# CITY OF ALBUQUERQUE

September 28, 2018

**RE: Fire Station #9**  
**Grading and Drainage Plan**  
**Engineer's Stamp Date: 09/14/2018**  
**Hydrology File: H20D043**

C-100

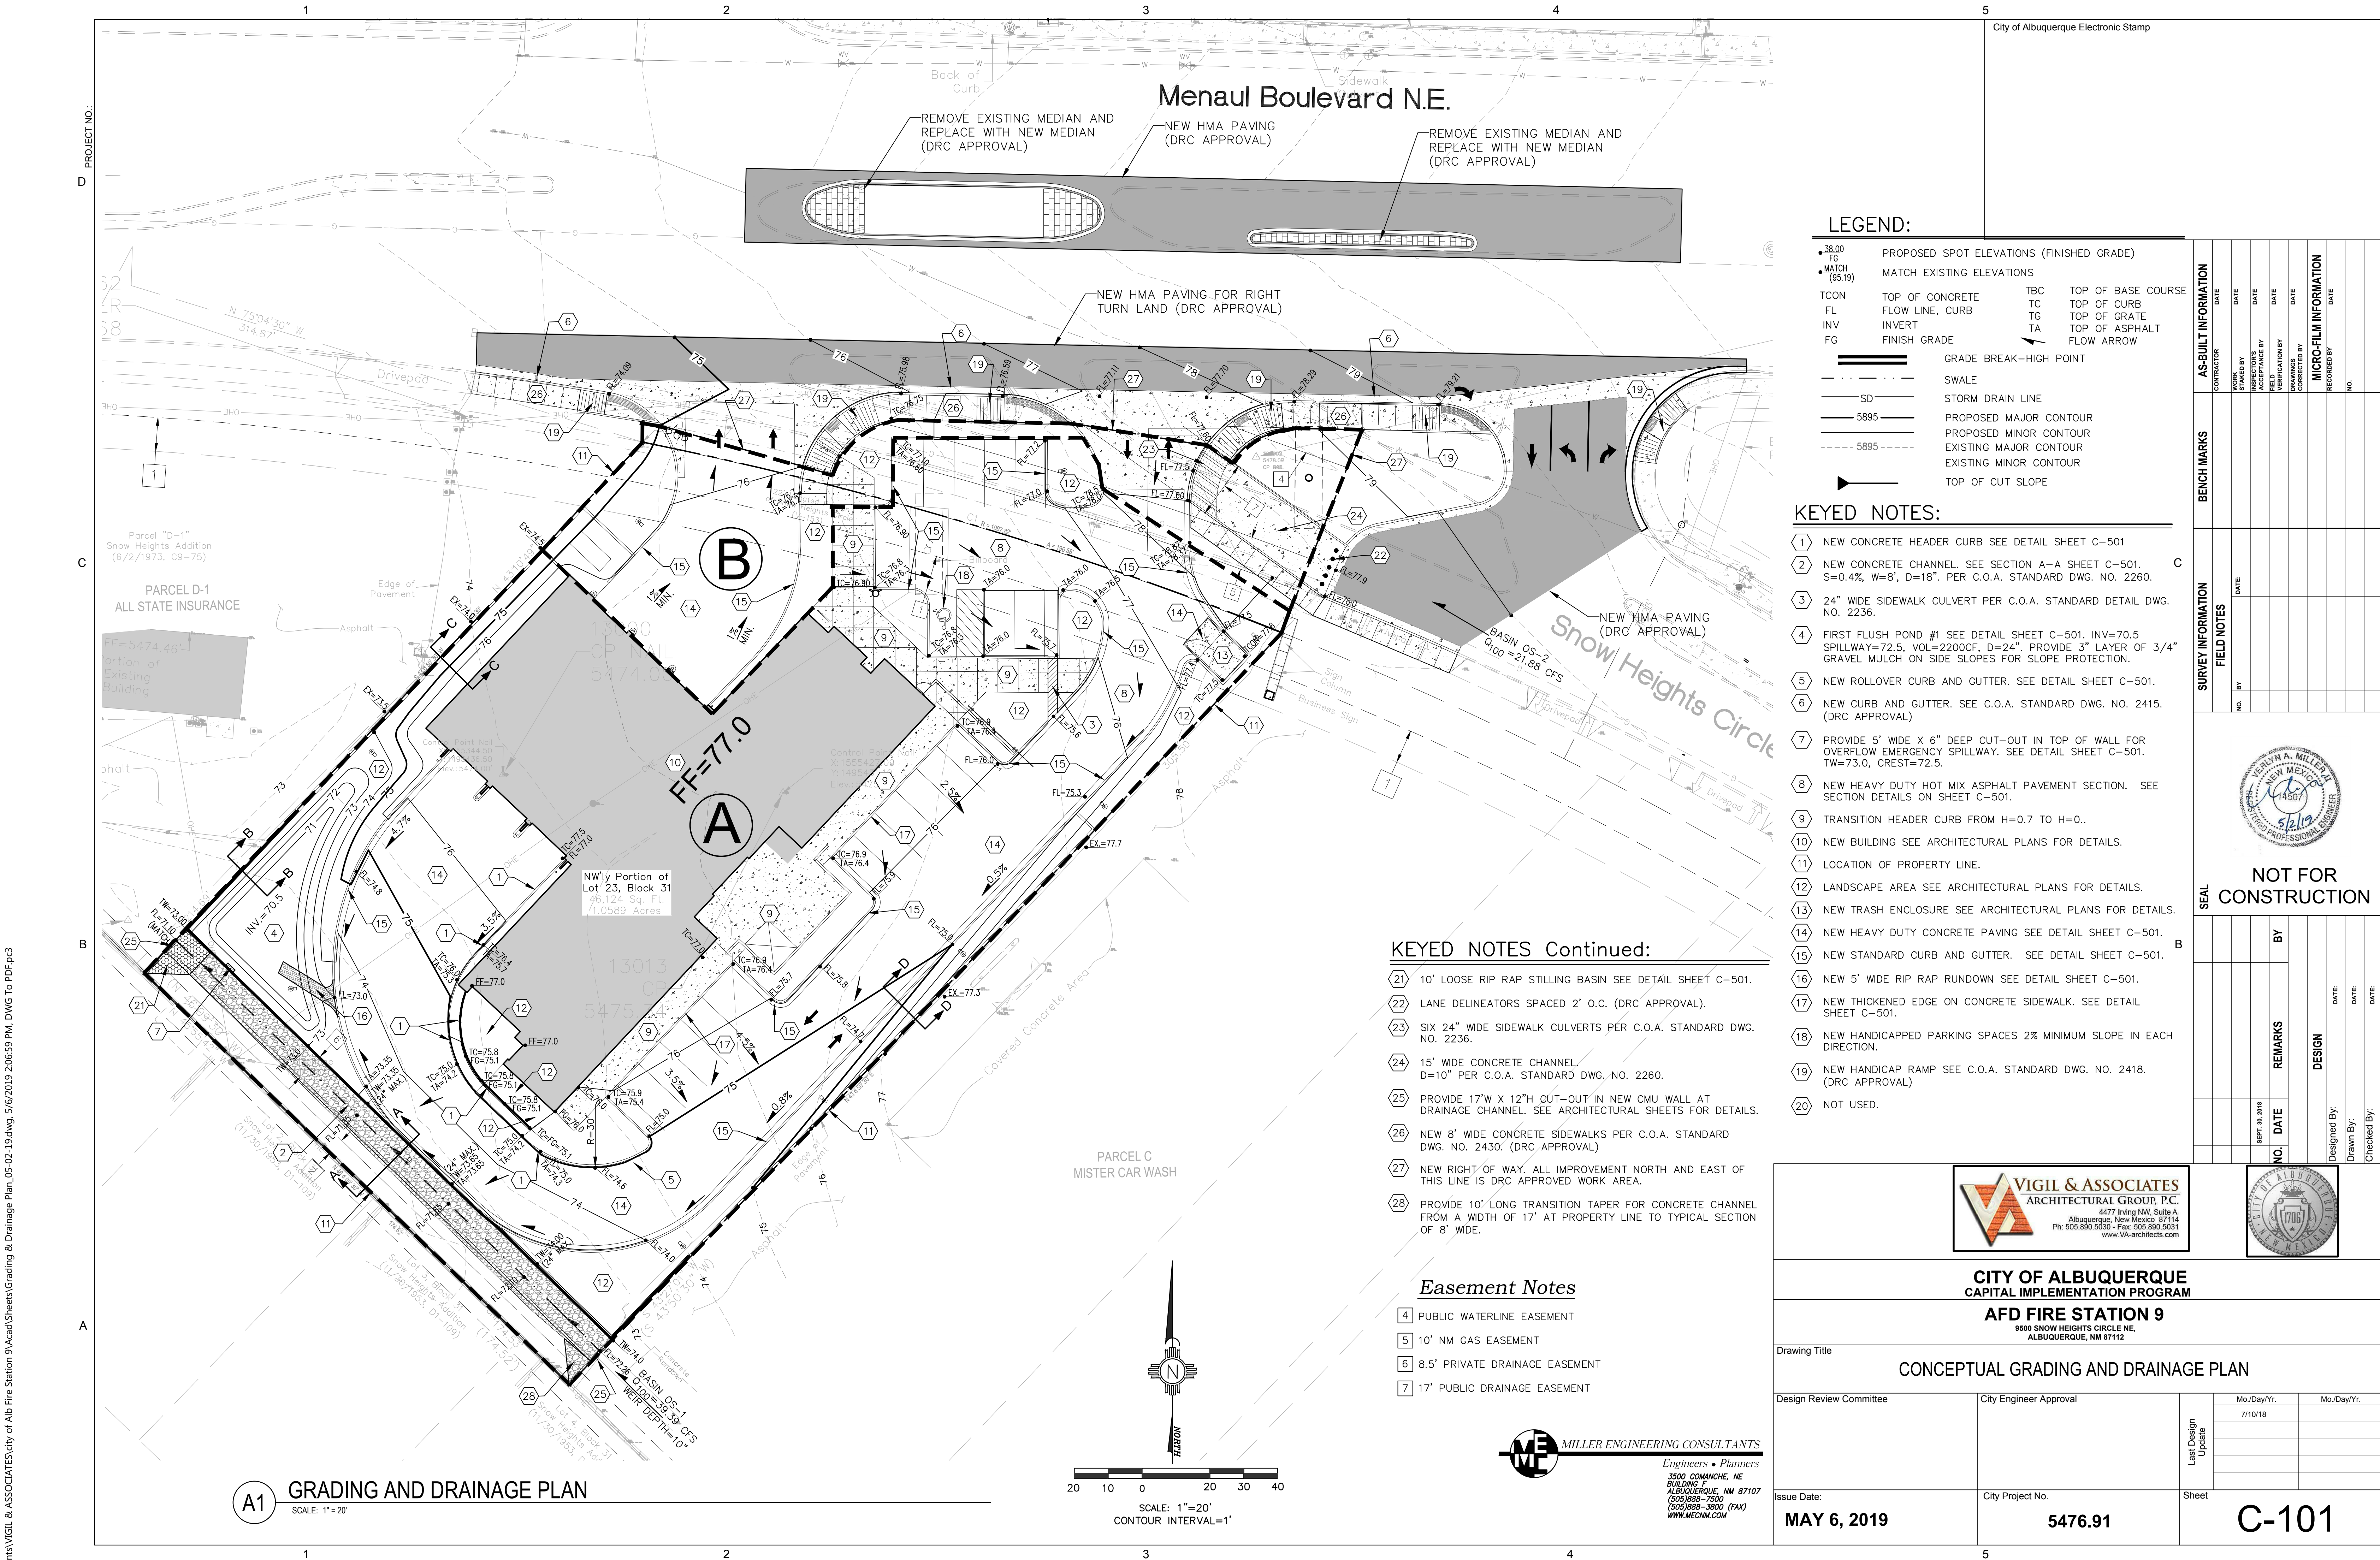
4. The parking lot on the north side of the building cannot be constructed in Menaul Blvd Right of Way as shown. The vacated portion of the Menaul right of way must be shown on the G&D Plan and the parking lot may not encroach into the right of way. The grading and drainage plan must identify new paths for the public drainage, and if it crosses the private property public drainage easements must be granted on the plat that will finalize the vacation. An additional private drainage easement must be shown on

5. This site has two drainage outfalls, one to Menaul Blvd at the northwest corner of the site and the second to Towner Ave through the southwest corner of the site. Onsite drainage basins to each outfall must be identified on the basin map. Calculations of the 100 year peak flow rates to each outfall must be shown on the plan together with hydraulic calculations demonstrating the adequacy of the conveyance systems.

6. The discussion of the existing and proposed drainage conditions and the conclusions should be modified to address both outfalls. Downstream capacity must be addressed in the discussion and be supported by calculations. If detention ponds are used to mitigate increased flows then a drainage report is required to include pond volume calculations and hydrographs.

7. Each first flush pond should be sized for 0.34" of runoff from the impervious area draining to it. The City doesn't give credit for extra volume in a pond over and above that which is required for the impervious area draining into it. Roof drainage patterns and drainage basins must be identified for the area draining to each pond and for any area that doesn't drain to a pond. A waiver may be requested for impervious surfaces not meeting the required first flush volume together with justification for requesting the waiver. The waiver request must state the area of impervious that won't drain to a pond and the associated first flush volume. Put all of the required first flush calculations together in one location on the G&D Plan.

8. The proposed contours must be labeled in the ponds and pond volume calculations must be included on the plan based on the area inside each contour.
9. Both the first flush and the 100 year water surface elevations must be labeled on each pond. Hydraulic calculations are required for the overflow from each pond to determine the 100 year elevation and to demonstrate the adequacy of the pond outfall structures. Typical sections, details, and construction specifications must be included on the plan for the pond outfall structures, and all other conveyance structures. Hydraulic calculations are also required for the rundowns into the ponds.

10. Typical sections are required for the north, south, east, and west boundaries showing the property line, existing and proposed grades, and horizontal and vertical maximum and minimum dimension. Include typical sections through ponds, retaining walls, and the adjacent sidewalk, curb and gutter, paving and valley gutters. Wall footings must not encroach into adjacent property without written permission from the neighbor.
